Application No: M/91/25/HH

Site Address: 15 Old Point Middleton-On-Sea PO22 7RY

Description of works: Two storey front, rear and side extensions. Loft extension. Internal alterations.

PROPOSED SECOND FLOOR PLAN

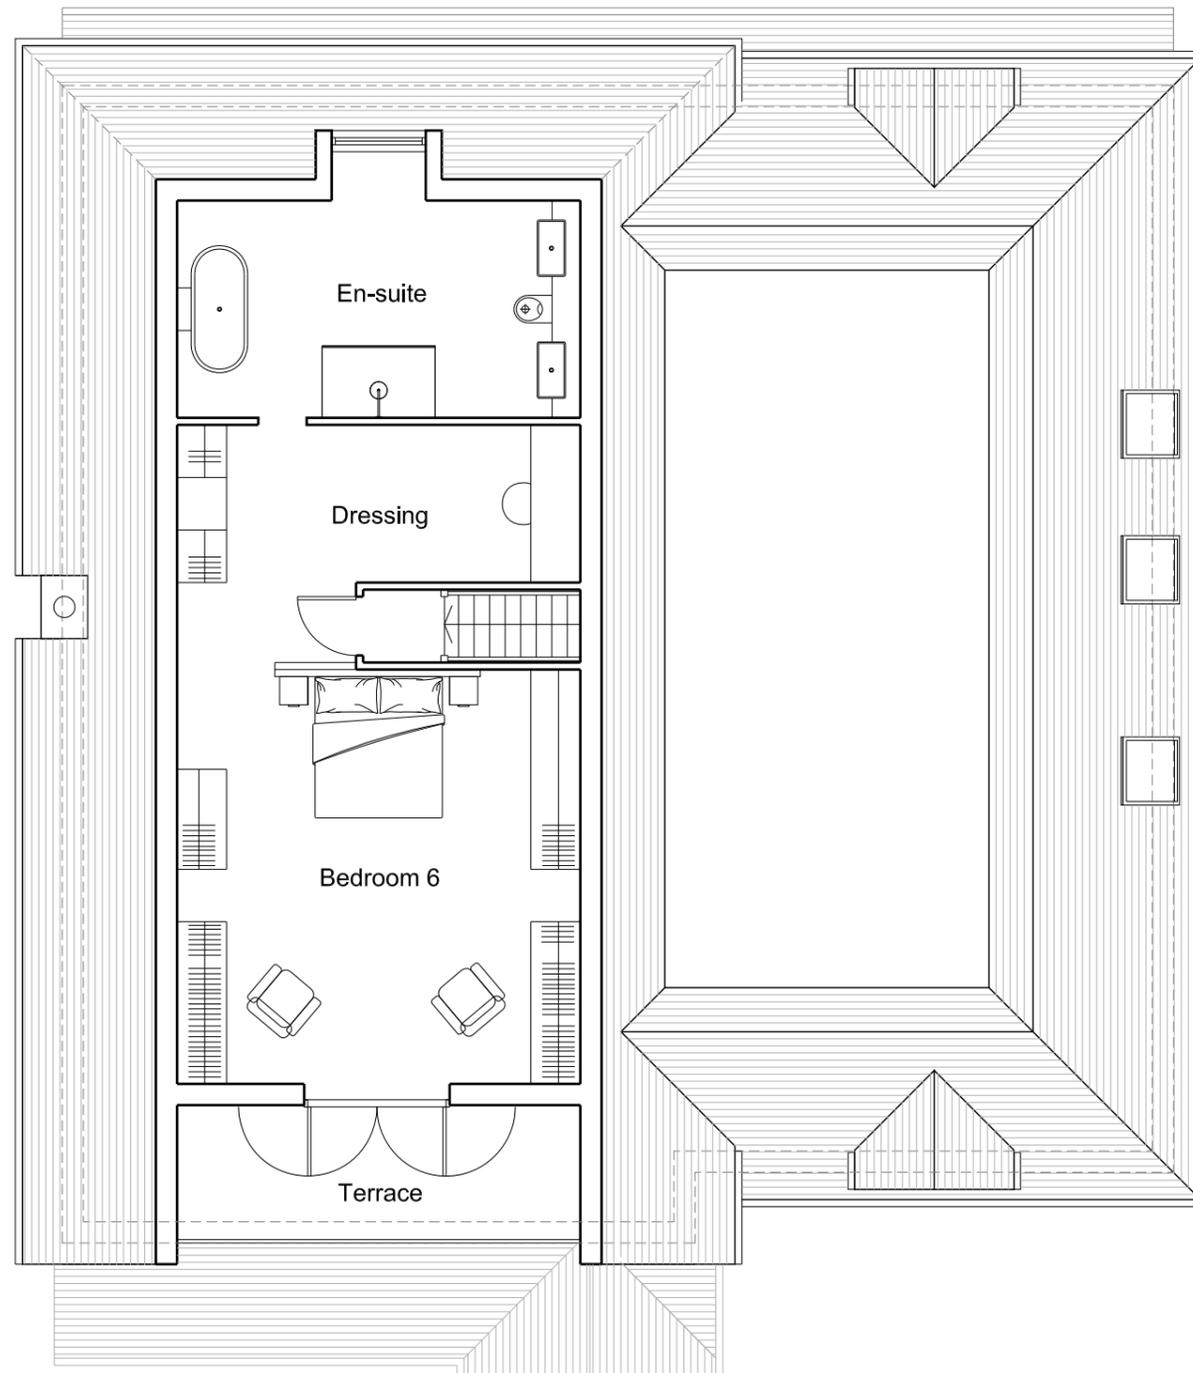
From a design perspective the proposals represent an improvement to the street scene and are largely compatible with the Village Design Statement (VDS) adopted by Arun DC as supplementary planning guidance for development Control Purposes, except in relation to the increased roof height and the inclusion of second floor accommodation featuring a balcony and double casement doors to the front elevation. This aspect is in conflict with the guidance set out within the VDS and the policies consistently pursued by MOSA and as such is considered to impact on the Area of Character. Our objection would however be removed were the roof height to be lowered and front elevation second storey fenestration removed.
